Your Ref:
Our Ref: 14492/APP/2025/2462

Location: 105 SAUNTON AVENUE HARLINGTON

Proposal: Erection of single storey outbuilding to rear garden

Application invalid on 26-09-2025.

DWG#- B/105/S-1.

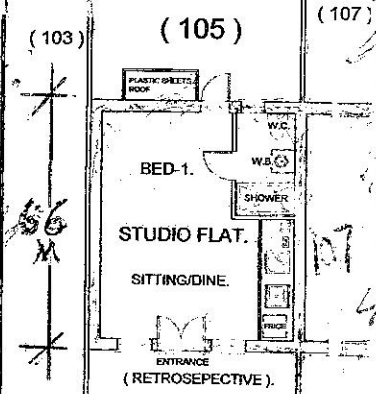
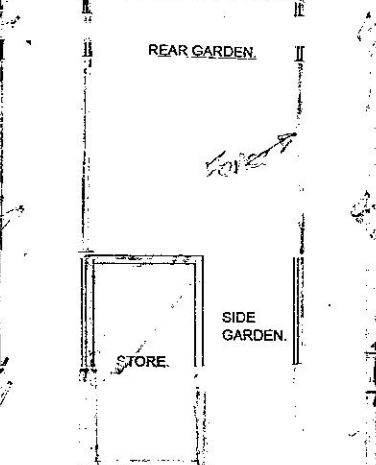
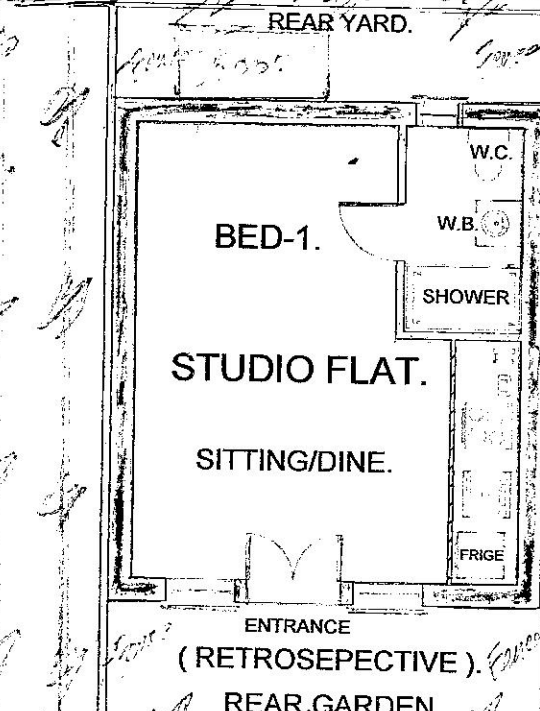
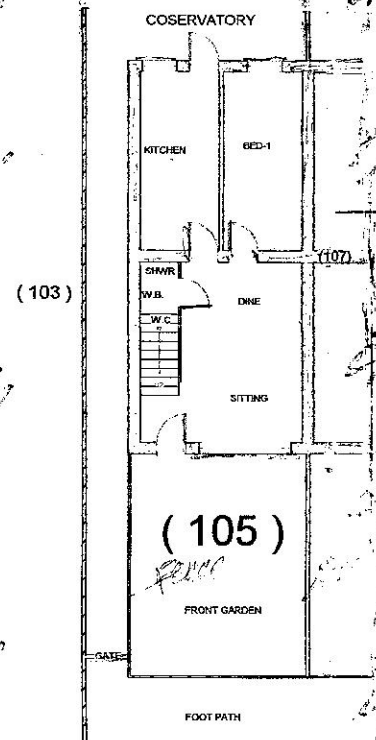
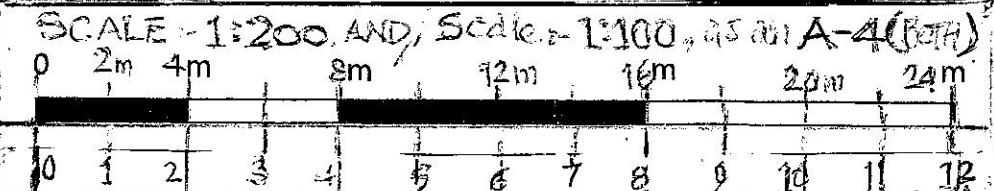
- ✓ 1) Pre-existing block plan
- ✓ 2) Existing and Proposed floor plans and elevations
- ✓ 3) Accurate scales of ALL plans that have been sent through - The submitted plans were not to scale.

- 1) Pre-existing block plan

Please check S-1, Amended 22/10/25
